Meeting Date : 3rd November 2014

Ref	Description	Address	Design award
10/312/14/001	Raise height of existing front boundary wall. This application may be determined under delegated powers by Littlehampton Town Council. This application affects the character and appearance of the Littlehampton Seafront Conservation Area.	13 Irvine Road Littlehampton BN17 5JB	DXE

NEW WALL TO FRONT
BOUNDARY

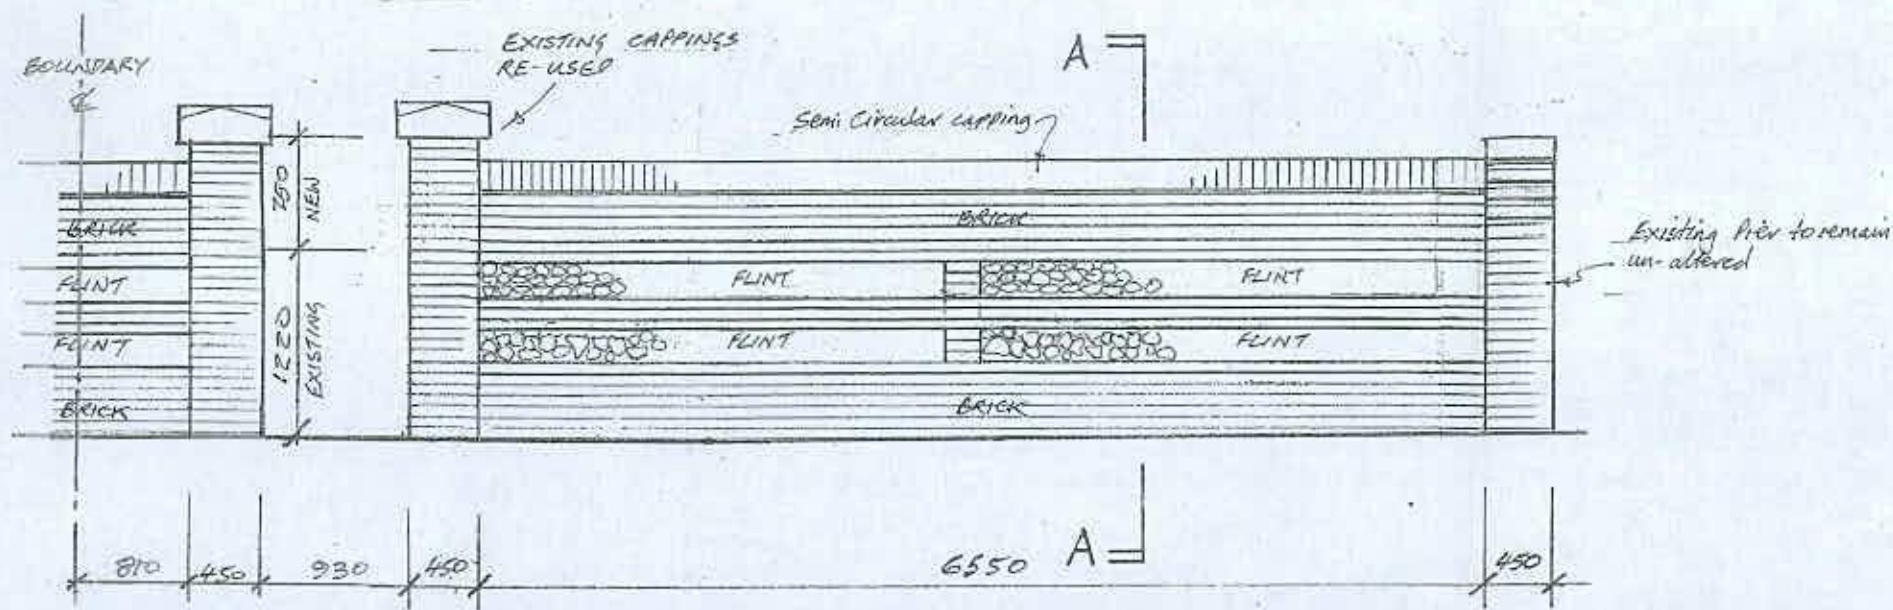
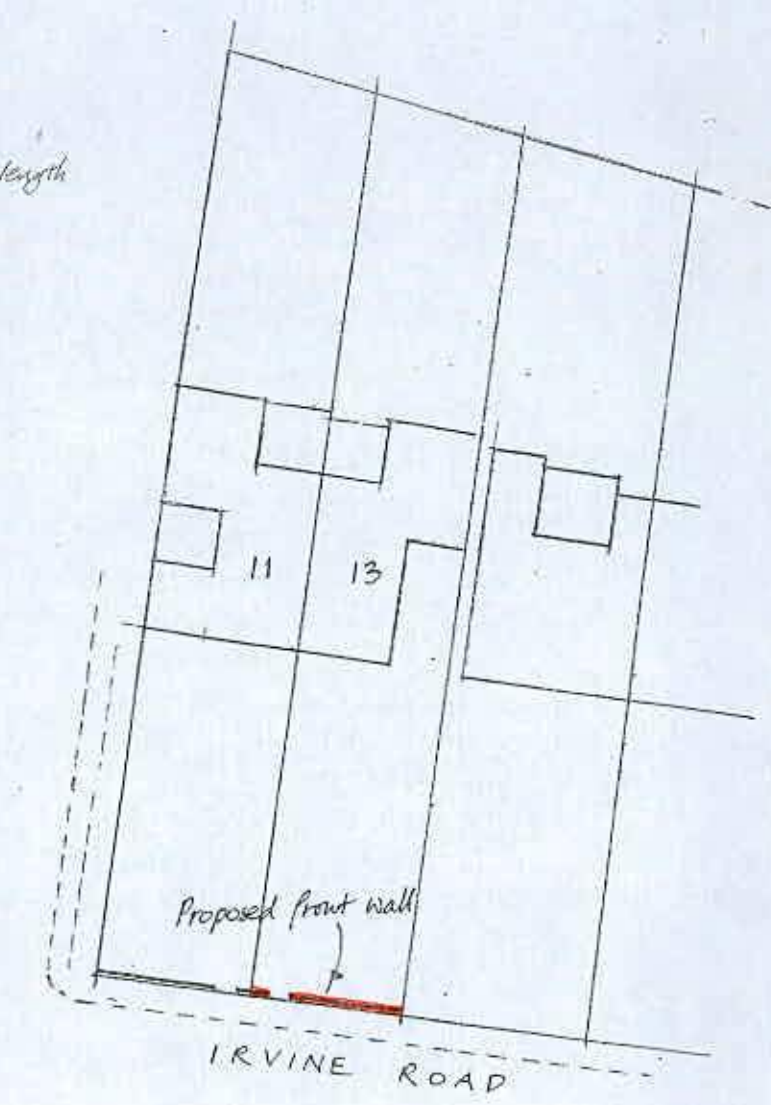
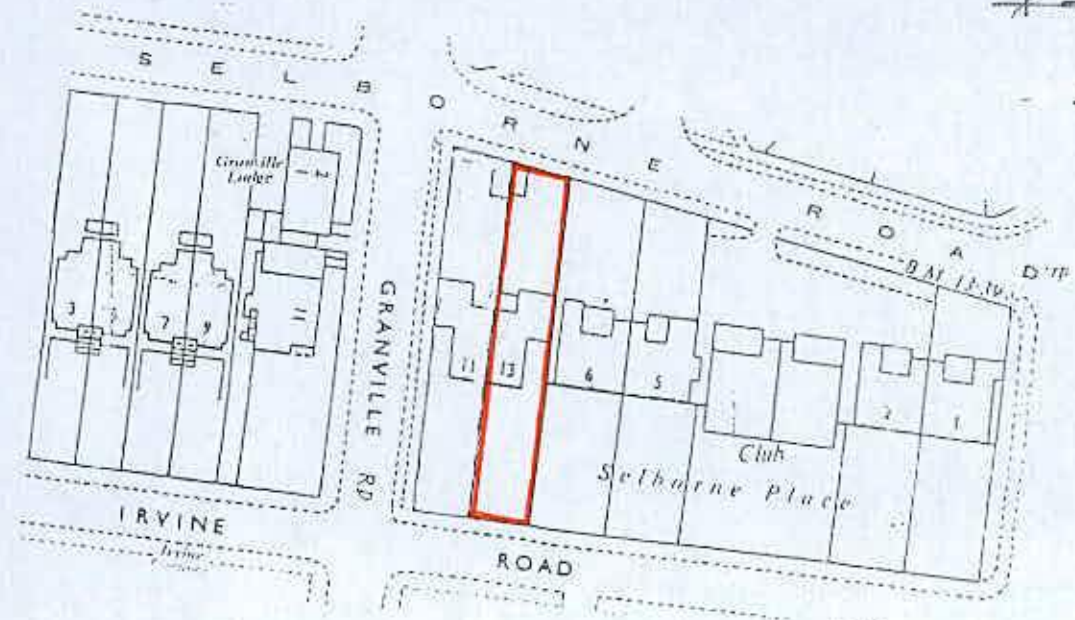
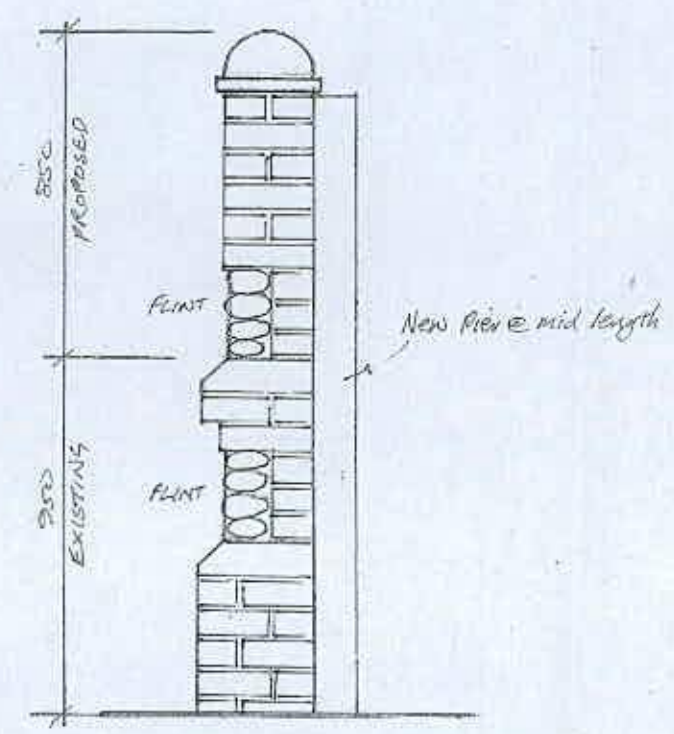
Objection for natural reasons - Suppressed longitudes - knowing for existing model - high plus one north

Ques: Would prefer the wood to be rounded across the door
but others the entire length of wall as on some hgs.

Perhaps the one who could explore both positions building
their own way rather than the same way as the existing
way of the industrial property
